**KIRKLEES METROPOLITAN COUNCIL
INVESTMENT & REGENERATION SERVICE**

DELEGATED DECISION TO DETERMINE PLANNING APPLICATIONS

Reference No:	2025/62/90527/E
Site Address:	Land adj, 67, Elm Tree Close, Norristhorpe, Liversedge, WF15 7BU
Description:	Change of use of land to domestic garden, formation of access and hard surfacing and erection of 2.0m high fencing, greenhouse and gazebo
Recommending Officer:	Nicole Helliwell

Officer Report

CLIENT:	MR J KAYE
PROJECT:	LAND AT LODGE LANE LIVERSEDGE WF15 7FG
DRAWING TITLE:	AS PROPOSED
PROJECT REF:	2025-060
DRAWING NO:	200
REVISION:	-
SCALE:	AS SHOWN @ A1
DATE:	FEB 2025

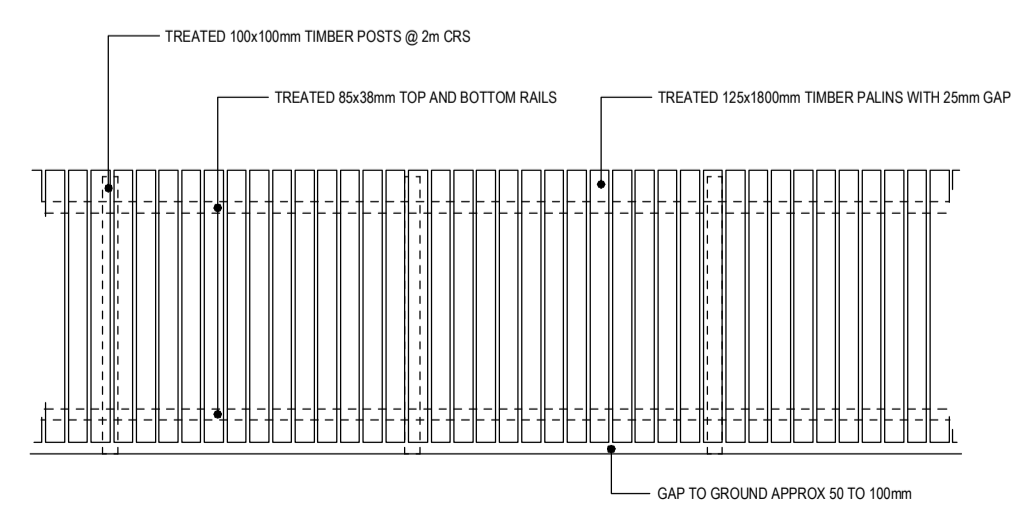
Amendments were sought during the course of the application. KC Highways Development Management did raise concerns regarding visibility and pedestrian/vehicle intervisibility. However, a revised site plan (reference no. 200 rev B) was submitted showing the fence set back to 1m from the carriageway edge of Lodge Lane, which was considered acceptable with regard to highway safety.

Whilst Highways Development Management had generally no objection to the use of the site for parking, officers did raise concerns regarding visibility and pedestrian/vehicle intervisibility. A revised site plan (reference no. 200 rev B) was submitted which shows the fence set back to 1m from the carriageway edge of Lodge Lane. Based on the revised drawing, KC Highways Development Management have no further objection to this proposal.

2. Within 3 months of the decision, the timber fence hereby approved shall be set back 1m from the carriageway edge of Lodge Lane in accordance with the 'As Proposed' drawing (reference no. 200 rev B) and thereafter retained.
